Planning Services Sign Permit Review Form

Date of Submittal	Application Number	Applicant	Landowner
11/15/18	CPSN 18-5004410	Reese Sign	Anderson Pooch LLC

Contact Person	Contact Number	Sign Location	PIN Number
Reese Sign	919-736-7883	6851 Overhills Rd	0504-98-8267

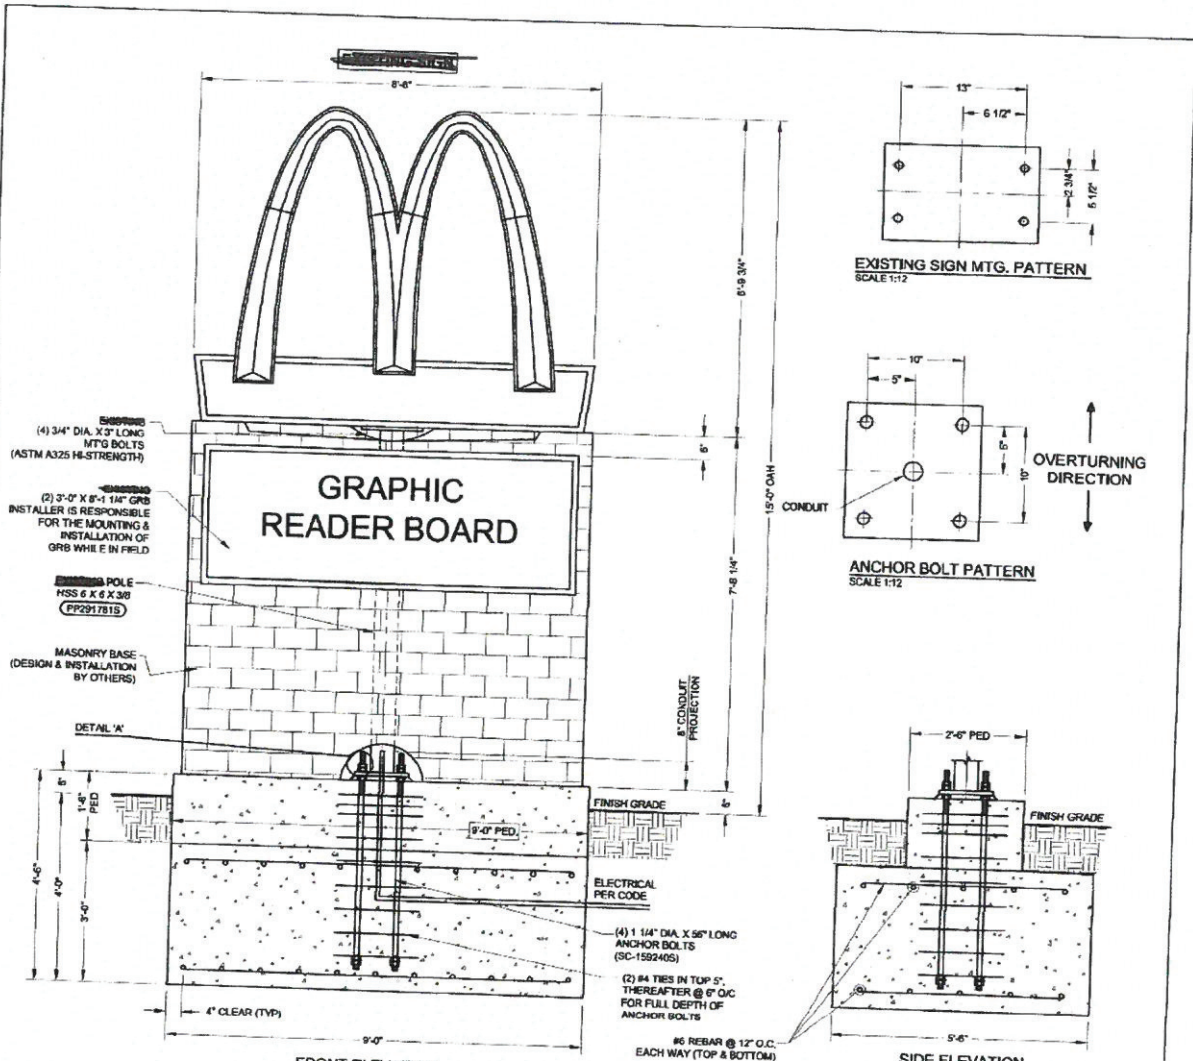
Comments	Graphic reader can't change more than 1 times/minute
----------	--

• Sign : 8'8" x 15'
 = 8.6' x 15'
 = 129 sq. ft

Reader Board = 3' x 8'1/4"
 = 3' x 8.104'
 = 24.312 sq. ft or
 18% of total sign area
